Memorandum
Planning and Urban Development Department
Planning Division

To: Elizabeth Boepple, Chair, and Members of the Portland Planning Board
From: Nell Donaldson, Planner
Date: July 21, 2016
Re: Mixed-Use Development, 23 Ocean Avenue
Project #: 2016-150 **CBL:** 129-G-1
Meeting Date: July 26, 2016

23 Ocean Avenue Association, LLC has requested a preliminary Level III site plan and subdivision review for a mixed-use development at 23 Ocean Avenue, at the corner of Ocean Avenue and Hersey Street near Woodford’s Corner. The proposed 7,000 SF development includes approximately 2,400 SF of office space on the basement level and first floor, and four two-bedroom apartments on the second and third floors. The proposal also includes new sidewalks on Ocean Avenue and Hersey Street, 10 off-street parking spaces with a lease for additional off-site parking, landscaping, and stormwater treatment. The site is currently occupied by a former residential building which has been converted to office use and a large lawn area. This open space would be developed under the proposal. The existing office building would remain.

**SECTION A-A' - RAIN GARDEN AND DRIVEWAY PERVIOUS PAVERS**  
NOT TO SCALE

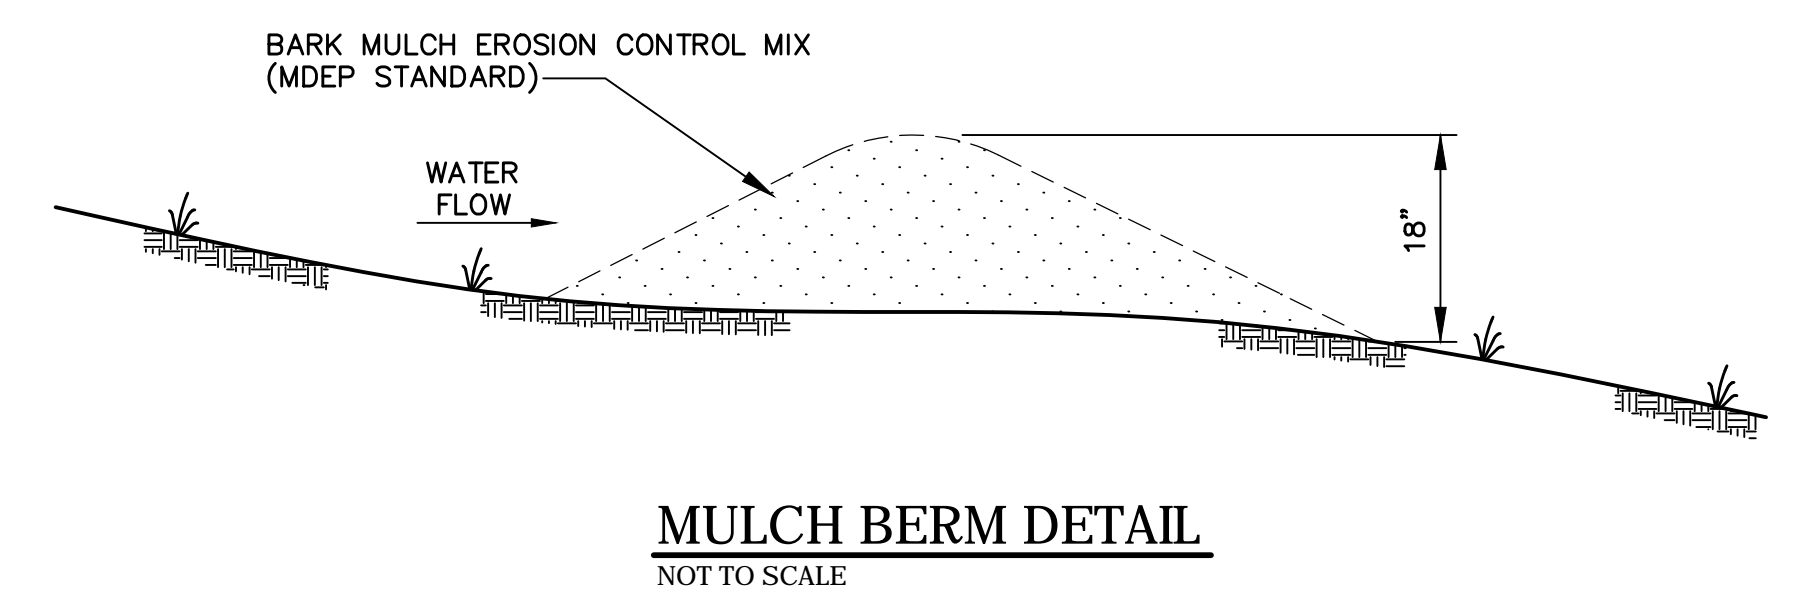
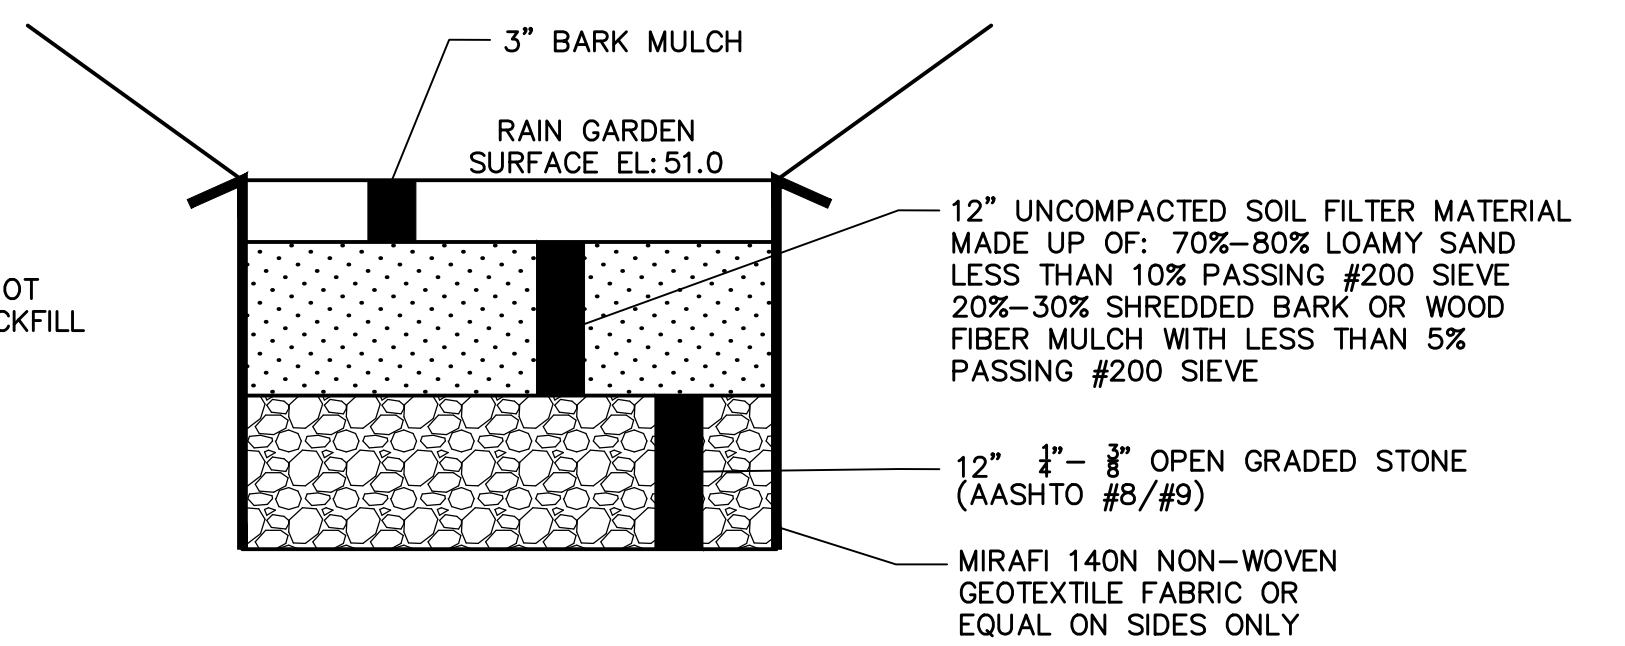
- *The proposed systems are anticipated to provide acceptable stormwater treatment, but the Applicant is required to provide calculations and additional design information verifying compliance with the Maine DEP Chapter 500 and City of Portland Technical Standards Section 5.*
- *The proposed rain gardens do not appear to have any overflow structures or bypass outlets. Applicant should provide model and information indicating the peak water elevations within these systems during storm events, as well as information on infiltration rates at these sites.*
- *The Applicant should provide comment on the potential for these systems to overflow during storm events, and the impact that this may have on their site and adjacent properties.*

The Applicant has requested that the outlet from one of the proposed rain gardens on the site be connected to the City of Portland combined sewer system in Hersey Street. Per Section 2 of the City of Portland Technical Manual, "the introduction of non-contaminated water such as rain water, non-contact cooling water, groundwater from foundation drains, sump pumps, surface drains or any other sources of inflow shall not be allowed to discharge into a sewer which conveys sanitary waste unless approved by the City Engineer." A waiver of this requirement may be considered when no other alternative exists. Before a waiver can be considered for this project, additional information on the anticipated flow quantities must be provided.

12 TYPICAL TREE PLANTING
NOT TO SCALE

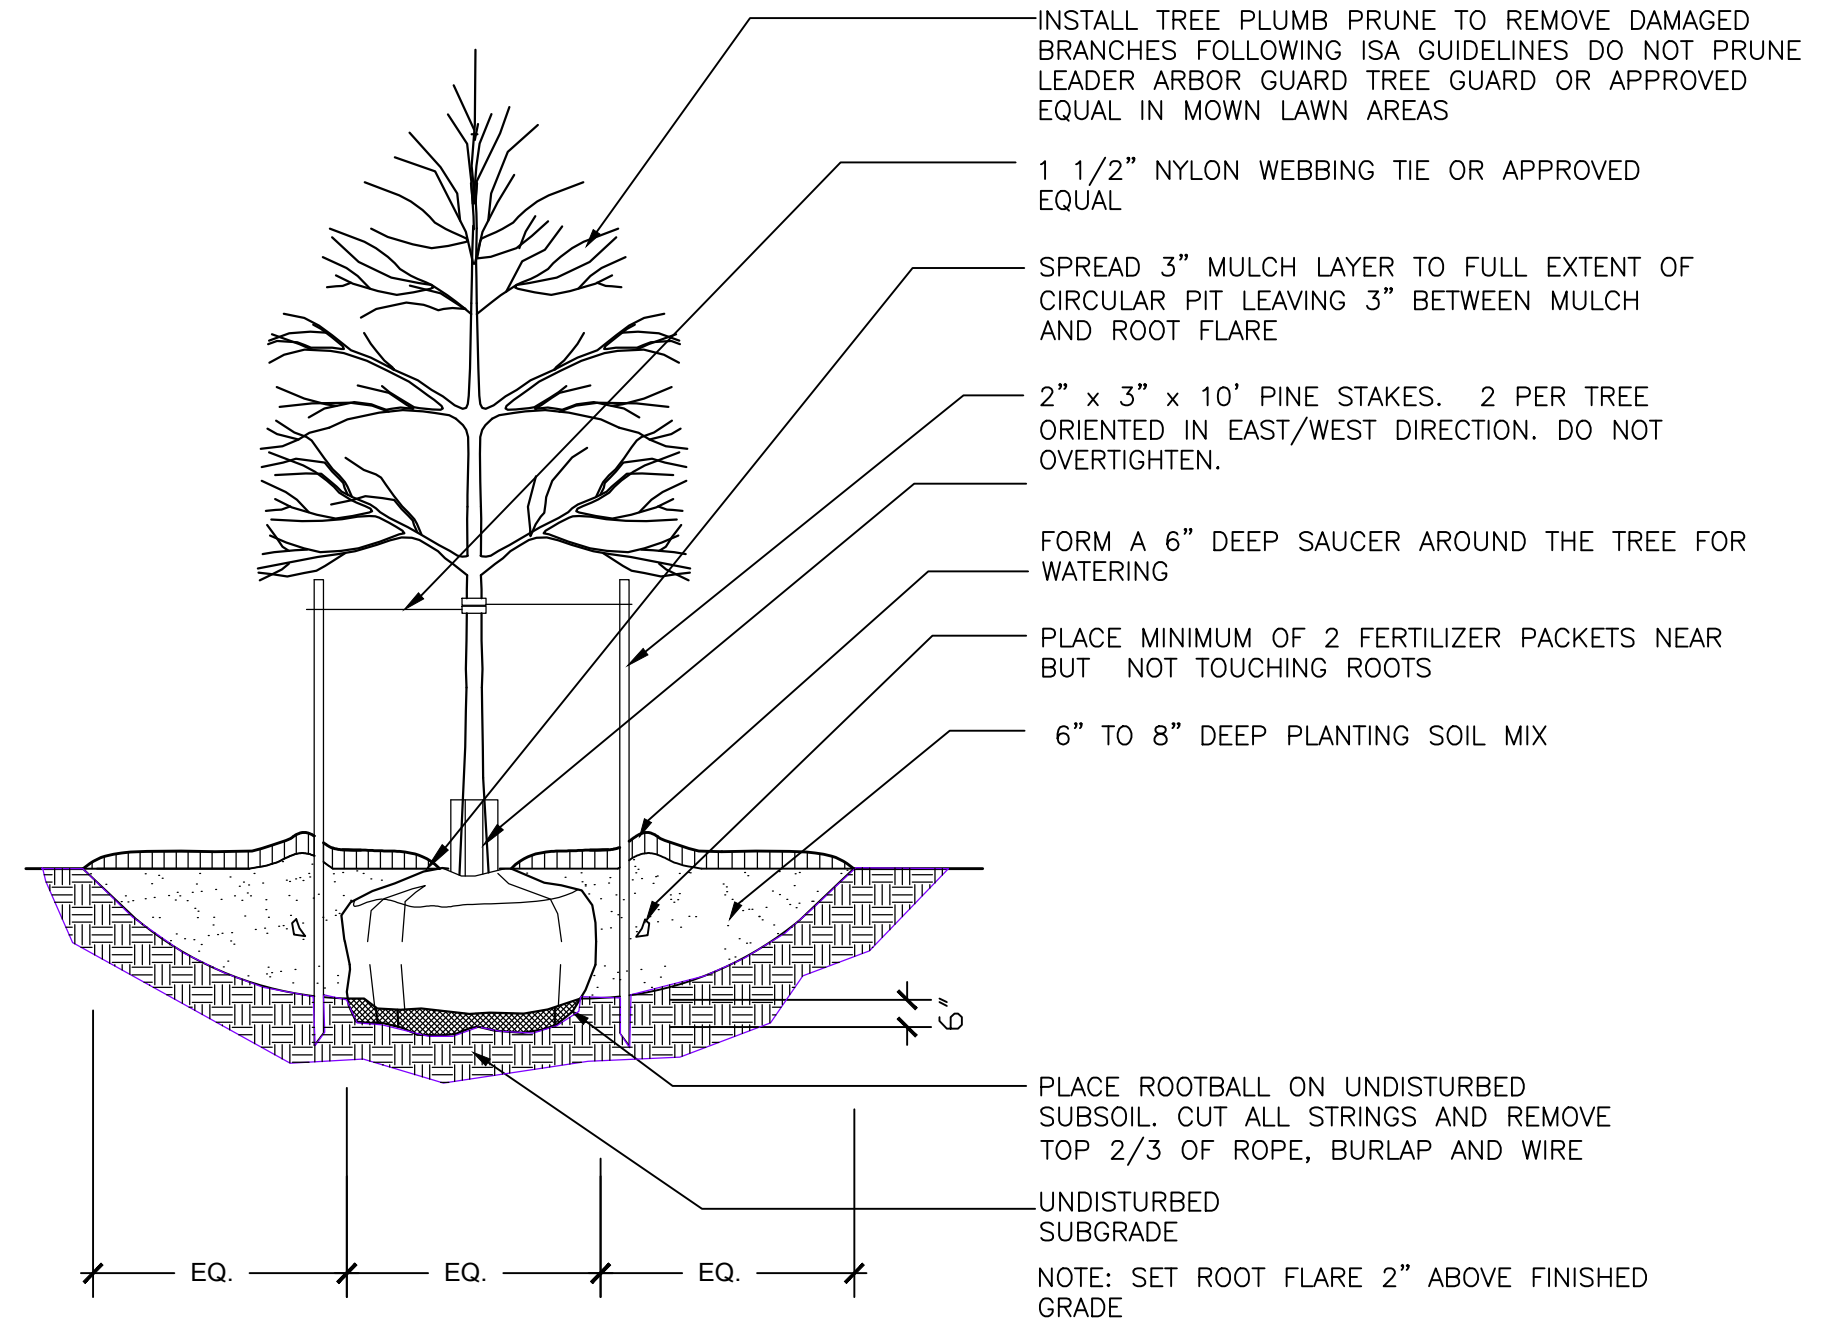
The existing esplanade width is problematic just too narrow to support Street trees on both sides, Ocean & Hersey Street. I checked the entire length of Ocean Avenue and no existing street trees, also this is a busy truck / commercial vehicle route and tree canopy even on an upright tree would unlikely to survive. Snow storage in winter along with deicing salts, this sidewalk route is on our priority school walk route and we plow so we need as much space as possible. Thus we would like to see 'setback' tree planting in available spaces.

REINFORCED CONCRETE DRIVEWAY APRON
NOT TO SCALE

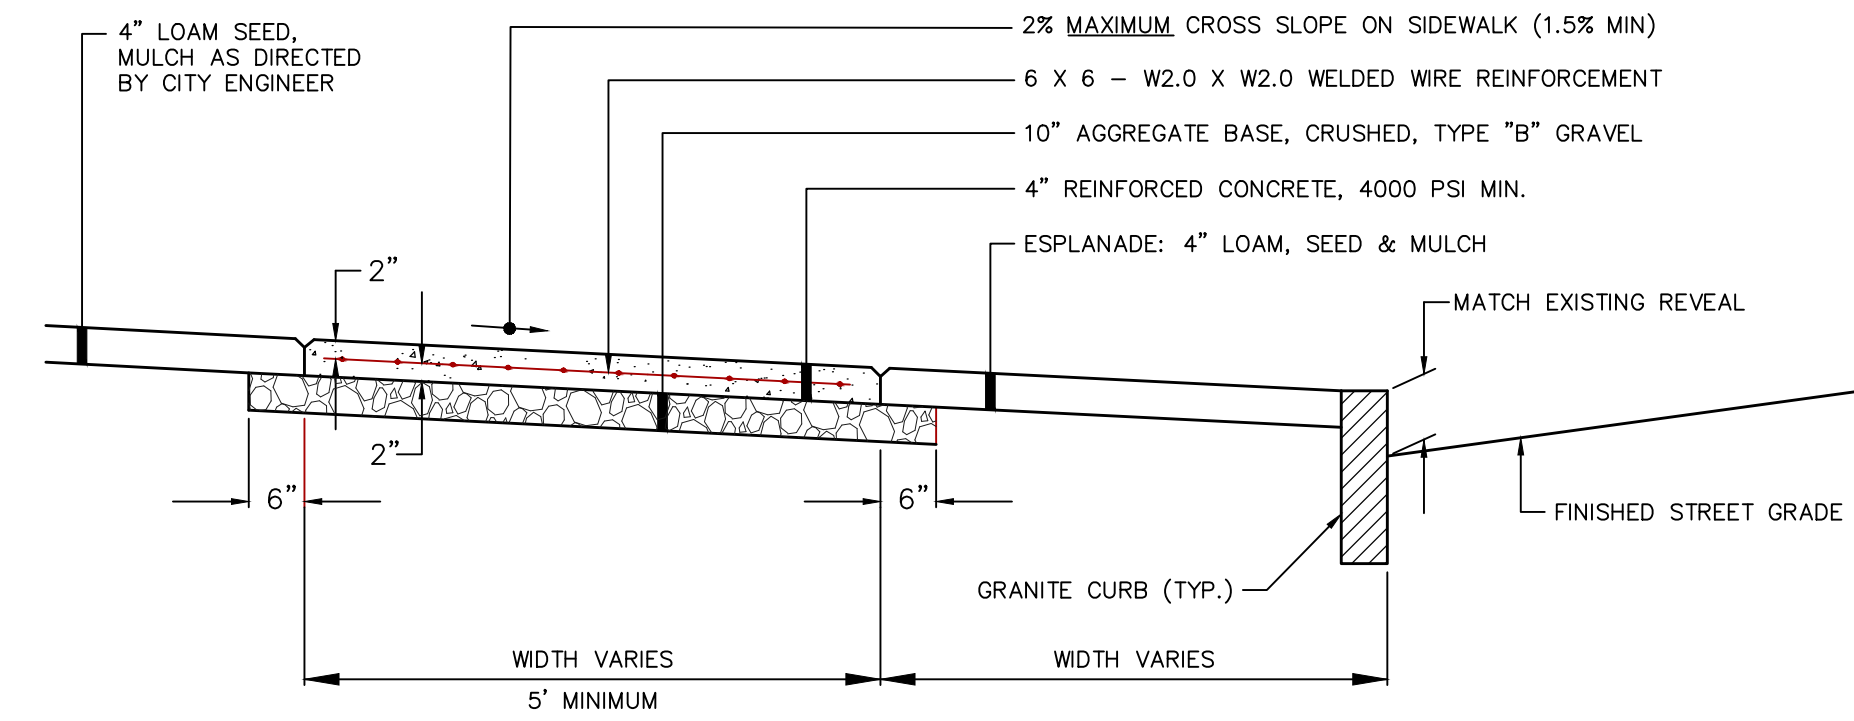
I find the driveway location and configuration to be acceptable given existing site conditions. A detail for the driveway shall be provided that notes that the crossslope shall not exceed 2%.
